Development Facilitation Team (DFT) – Review Comments

Project No: PR-2025-020067 Date: 6/25/2025 Agenda Item: #7 Zone Atlas Page: H-16

Request: Eliminate lot lines to create 2 new tracts from 4 existing tracts. Vacate and relocate existing 30' private access and drainage easement. Dedicate 4' RW along Vassar.

Application For: MINOR PLT-2025-00021 – MINOR PRELIMINARY/FINAL PLAT

EXISTING CONDITIONS, VACATIONS & DEDICATION

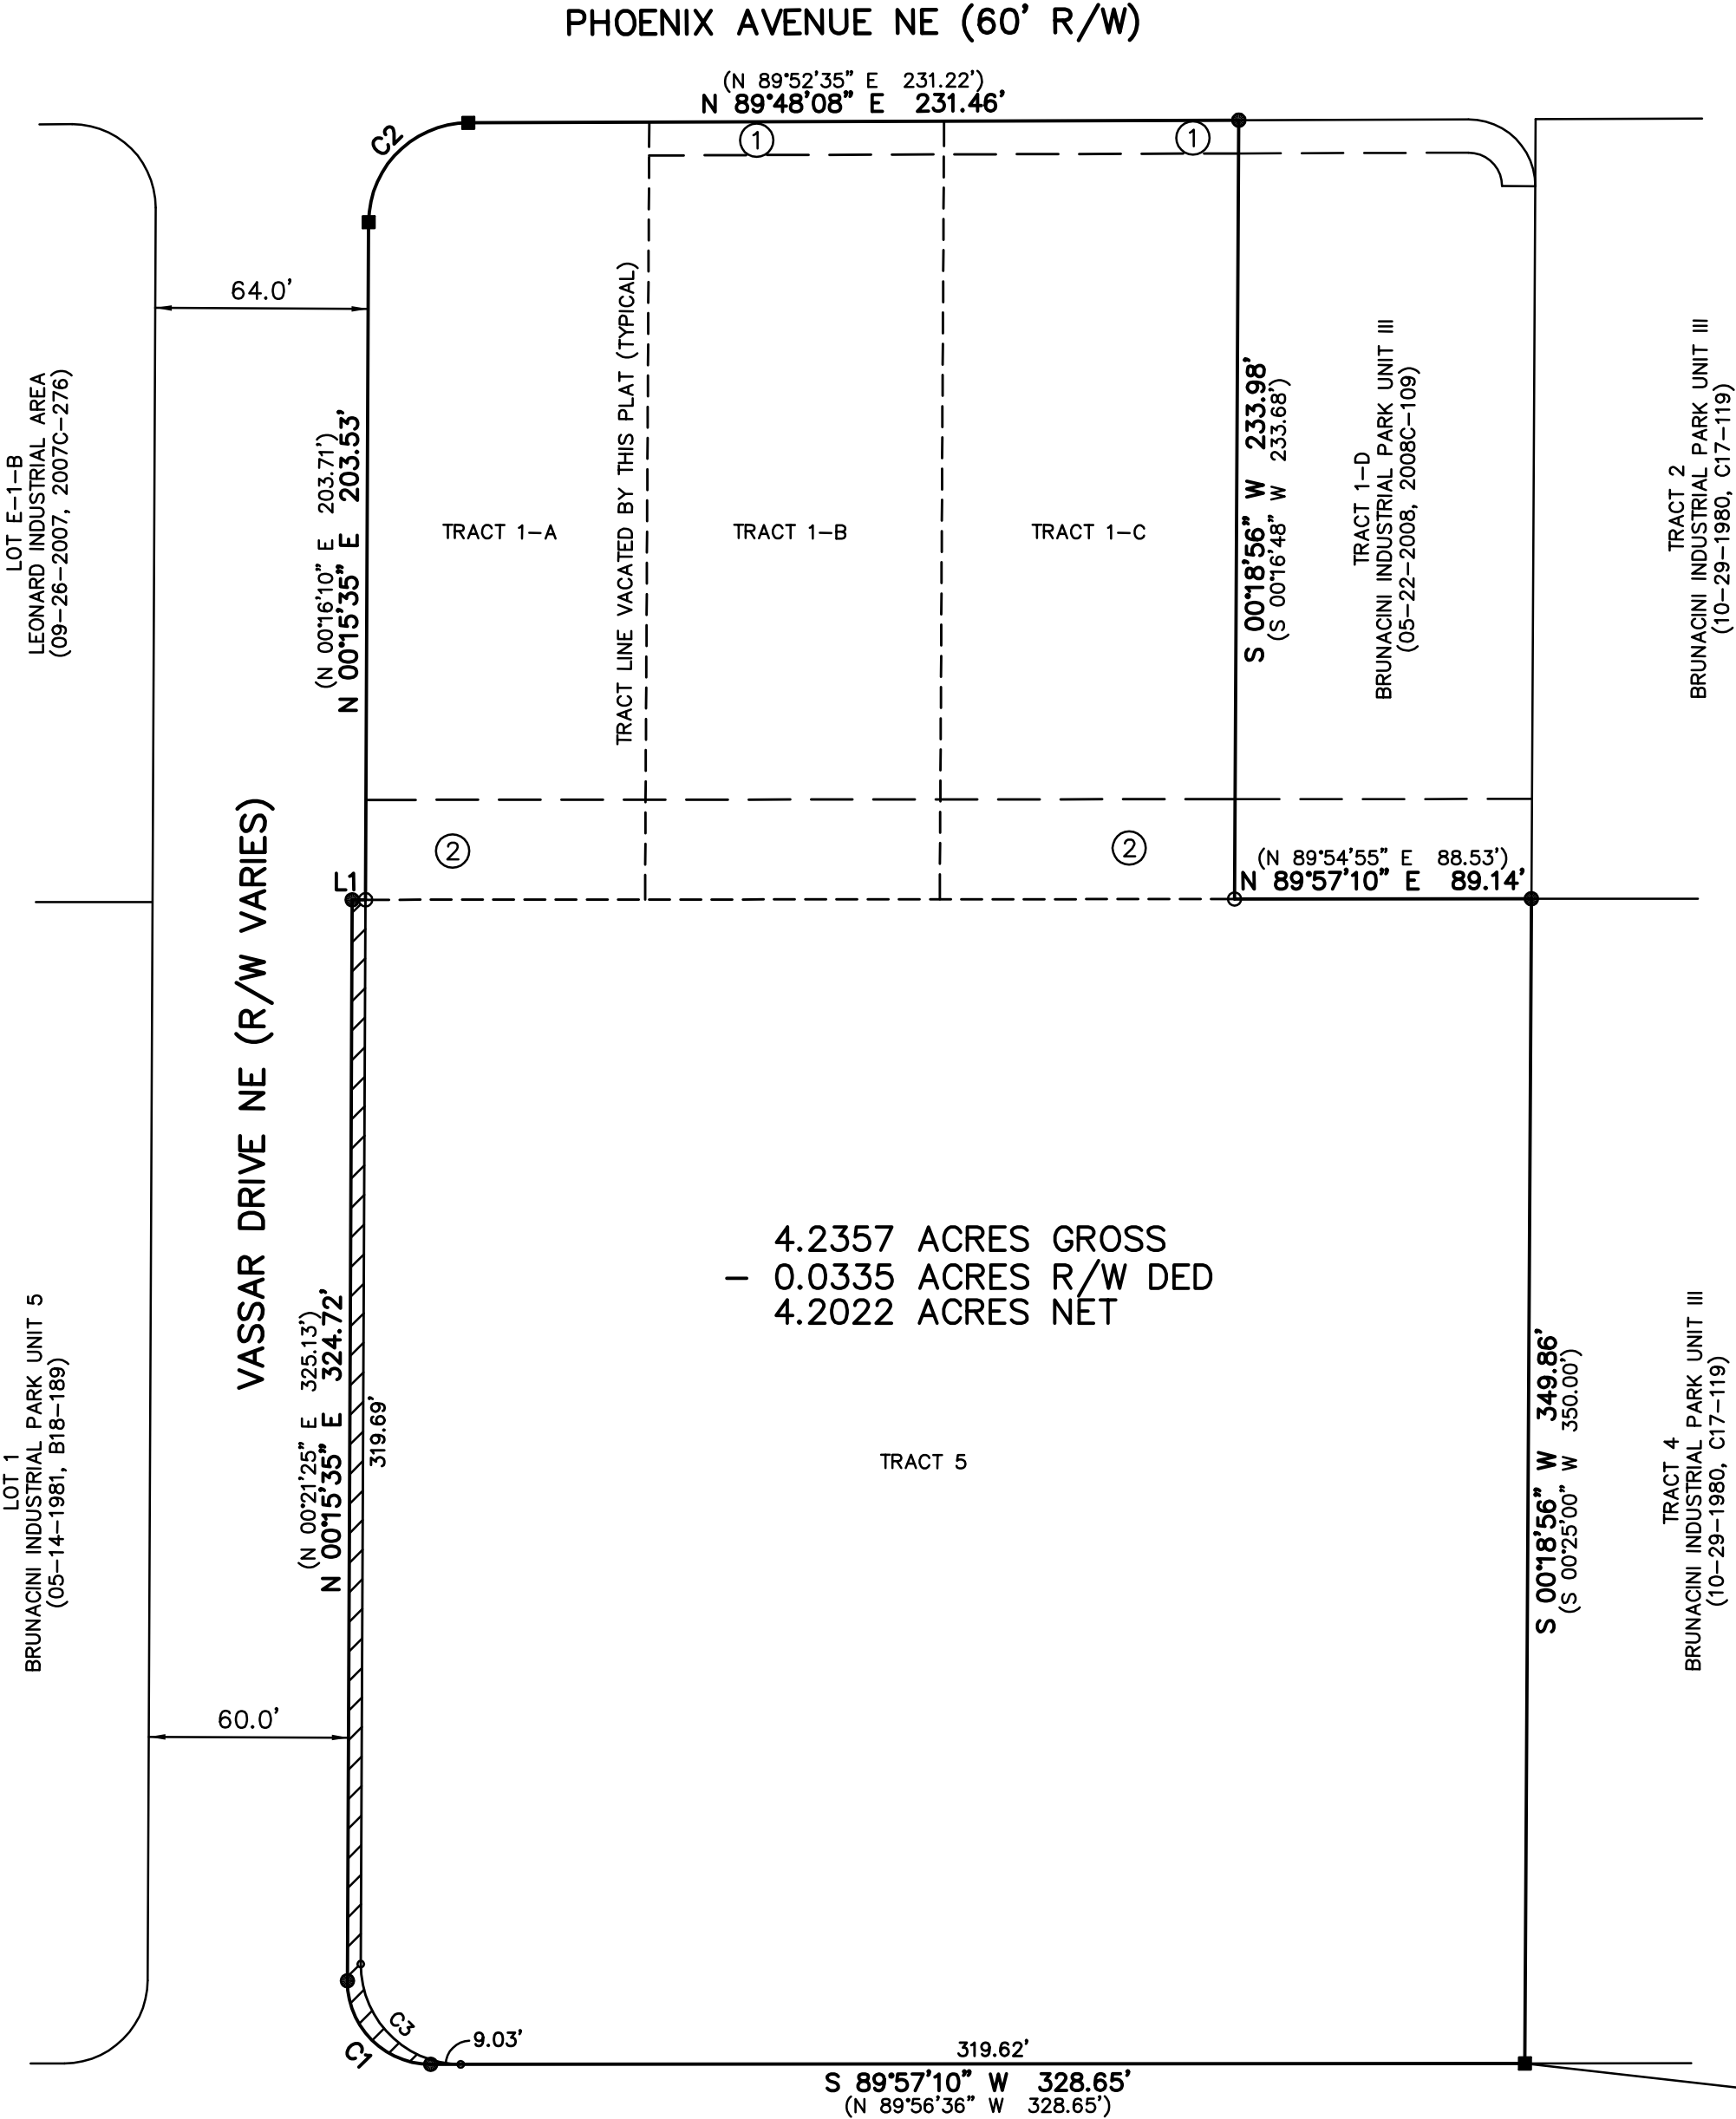
- Please confirm original and updated details of the site for the DHO. Proposed Preliminary/Final plat, vacation, and easements.
- Per Transportation, the site is not meeting DPM requirements for sidewalk width and landscape buffer. *Clarify if the Infrastructure List (IL) will need to be modified.

- Please clarify the Hydrology/Storm Water waiver application included in the submittal.
- Clarify access from Menaul and the continuing access easement through Tract 5. Is that platted access? Will it affect the vacated area? Is there cross-access? It appears to be the only access to the abutting properties.

1. *The first easement to be vacated (as indicated by keyed note "1" on sheet two of the proposed plat) and applied in ABQ-PLAN under VAC-2025-00026, is a private 10-foot drainage easement, which was established in 2008.*

2. The second easement to be vacated (as indicated by keyed note “2” on sheet two of the proposed plat) and applied in ABQ-PLAN under VAC-2025-00022, is a 30-foot private access and drainage easement and was established in 2008. The easement crosses a property that is not owned by the applicant, though both the applicant and adjacent property owner that shares the easement are in agreement with the proposed vacation. The easement will be replaced by an easement with the same width and purpose, only shifted 25-feet to the south (as shown on page three of the proposed plat). Since the easement is wholly being replaced, and the applicant and adjacent property owner are in agreement; the public welfare does not require that the 30-foot private easement be retained. The new easement will allow for access to the lot to the east (Tract 2), which is also owned by the applicant and will not require access through Tract 1-D (which is not owned by the applicant).

Drawn By:	TA	Date:	03-11-2025
Checked By:	TA	Drawing Name:	24156PLT.DWG
Job No.:	24-156	Sheet:	3 of 3

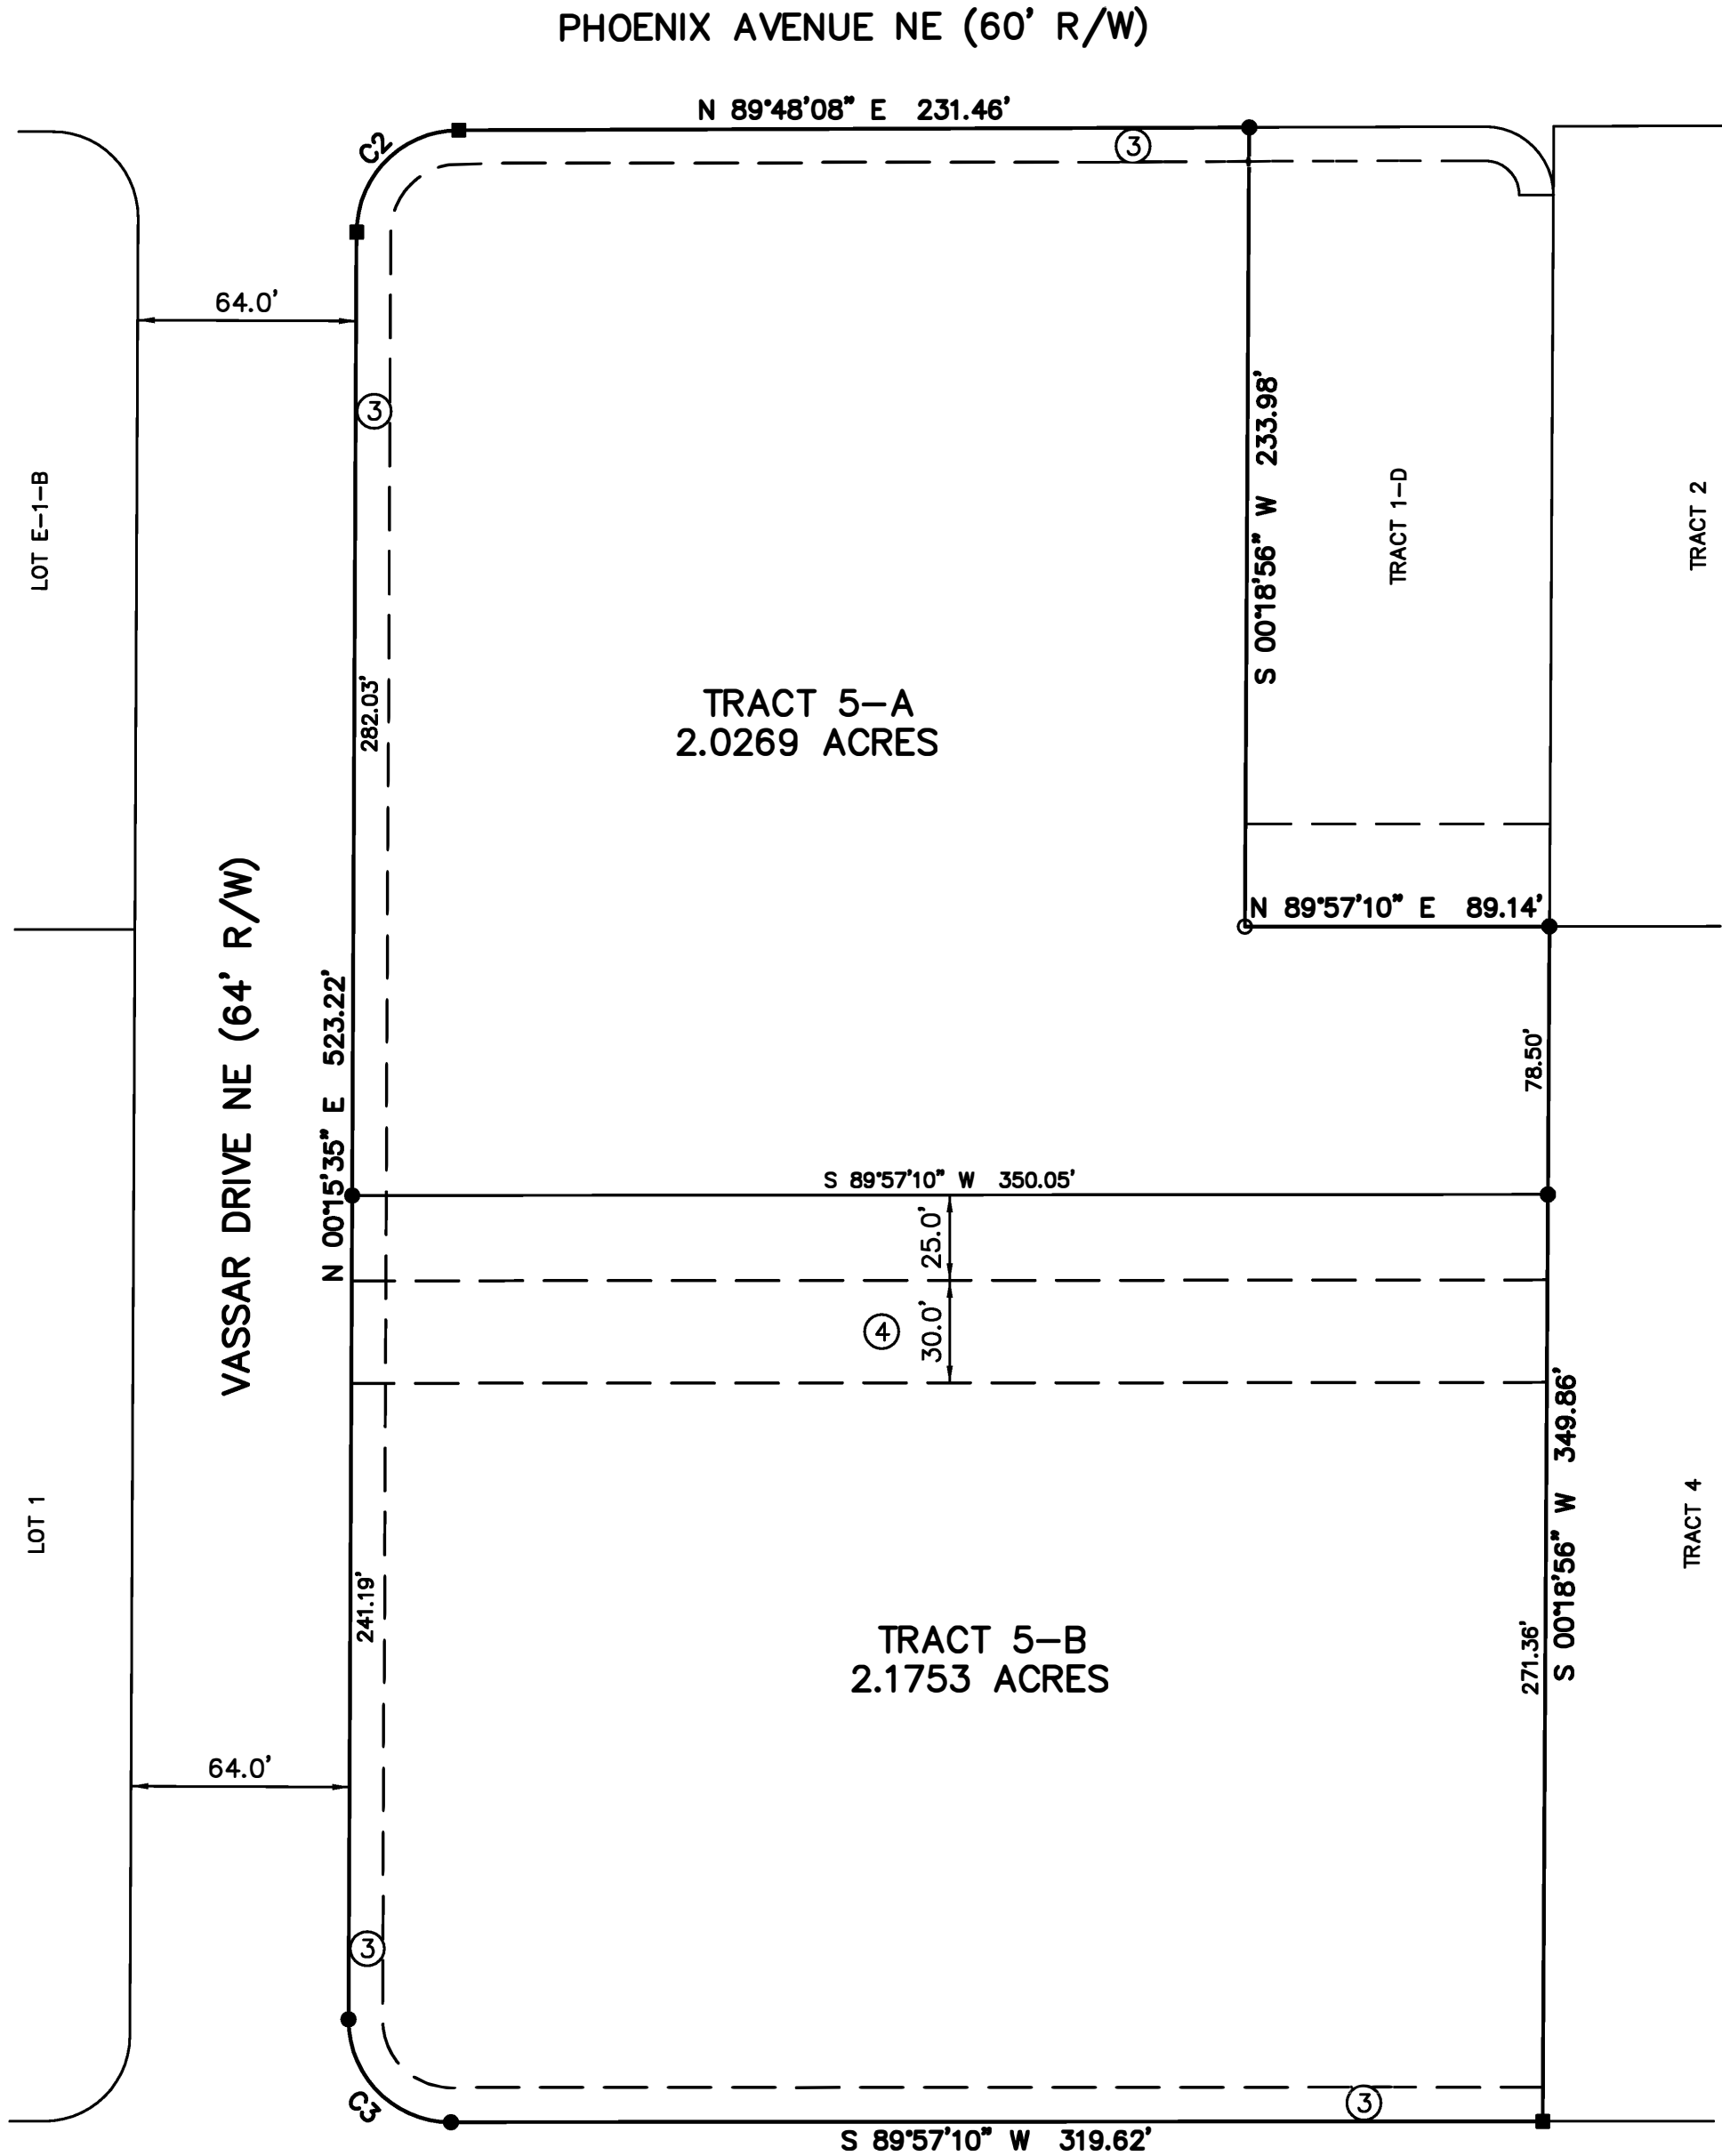
1. There are no easements being granted and the note regarding Water Authority easements can be removed.
 - a. Please add the following note on the proposed plat. (Previous comment)
 - i. “Existing public water and/or sanitary sewer infrastructure may not be constructed or sized to adequately serve potential future development. Improvement or upsizing of existing public infrastructure may be required as a condition of future development approval.”
2. For future development, please place a Request for Availability online at the following link: http://www.abcwua.org/Availability_Statements.aspx. Requests shall include fire marshal requirements.

The vacation of the 10-foot drainage easement will benefit the public as a new 10-foot public utility easement will be established in its place (see sheet three of the proposed plat), which is a more efficient use of the property. The proposed warehouse development will be a net benefit to the public welfare as it will establish an essential industrial use and facilitate the development of a vacant lot. Speaking generally, vacant lots can be detrimental to neighborhoods and surrounding properties.
